Your ref: MP09_0182-Mod-8

Boggabri Coal Mine – MOD 8 – Increase in Depth of Mining

Attachment A – BCS's Recommendations

Attachment B – BCS's Detailed Comments

**Figure 2: MOD 8 Conceptual Project Layout (JBA, 2022b)**

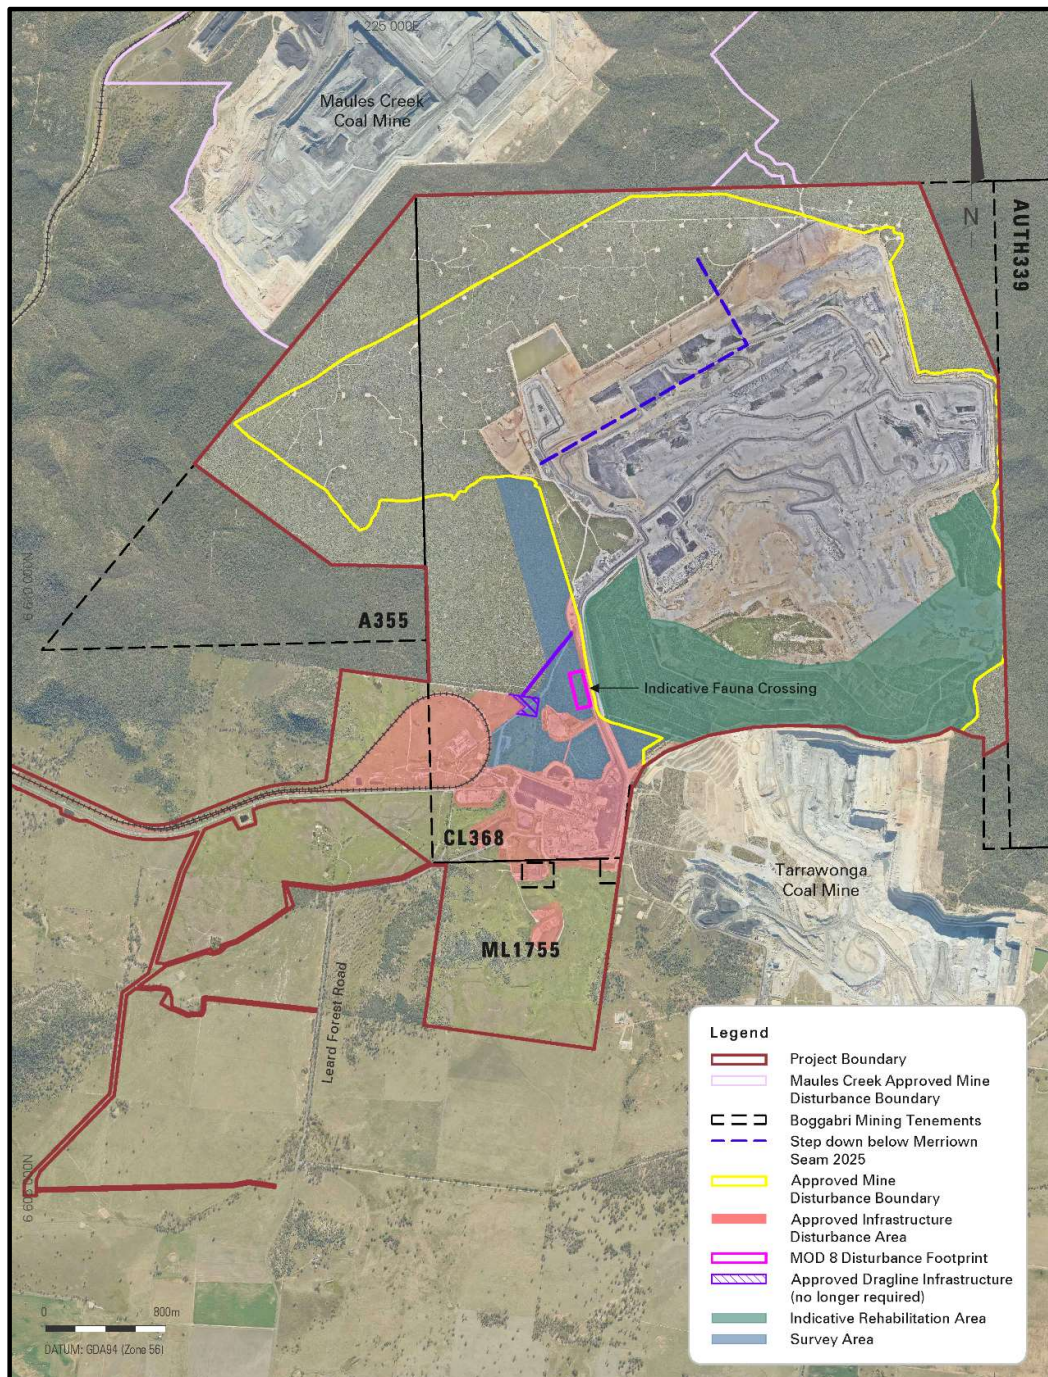
2. The detail of the fauna connectivity structure which is being proposed is unclear and should be clarified

Several key aspects regarding the proposed fauna crossing are unclear, this includes, but is not limited to:

- The type of structure proposed i.e. canopy bridge, vegetated overpass
- The specific species of fauna which are expected to utilise the proposed structure; and
- Why the proposed location of the structure was chosen and how this location provides the best opportunity for habitat connectivity and fauna movement in the landscape surrounding the mine site.

The BDAR states that the proposed design of the fauna crossing will be determined post-approval. However, an adequate understanding of what structure is being proposed is essential for BCS to consider the efficacy of the proposal and understand if all potential impacts resulting from the proposed development have been adequately captured in the BDAR. This information cannot be deferred to a post-approval stage.

The efficacy of the proposed fauna crossing and willingness for fauna species to utilise the crossing have not been addressed. This includes, but is not limited to:

- The immediate adjacency of the proposed fauna crossing to heavy infrastructure areas within the mine site and the potential for this to affect the willingness for fauna species to utilise the crossing.

- The level of disturbance likely to arise from the mine haulage road the fauna crossing is proposed to cross and how this disturbance may affect the willingness for fauna species to utilise the crossing.

- The connecting patch of vegetation to the west of the proposed fauna crossing appears to be already disconnected from any larger patches of vegetation, owing to the following obstructions to its connectivity:

- o Leards Forest Road to the north,
 - o A mine road leading to a water retention basin to the south; and
 - o Cleared agricultural land and infrastructure to the west.

The above listed obstructions to connectivity would likely create a series of gaps around the proposed fauna crossing by which some species may physically be able to cross but would be unwilling to do so because of unfavourable ambient conditions or perceived risk. An aerial image of the proposed location of the fauna crossing showing the surrounding obstructions to fauna connectivity have been provided below in Figure 1.

2.1. The BDAR must clearly describe the structure proposed to be constructed.

- 3.1. Address the limiting factors which may affect the efficacy of the proposed fauna crossing and willingness for fauna species to utilise the crossing.
 - 3.2. Provide clear justification of the net biodiversity outcomes and benefit to be achieved through the proposed fauna movement crossing against the extent of impact required for its construction.
4. Additional information is required to inform the surrendering of the dragline erection pad and walk road
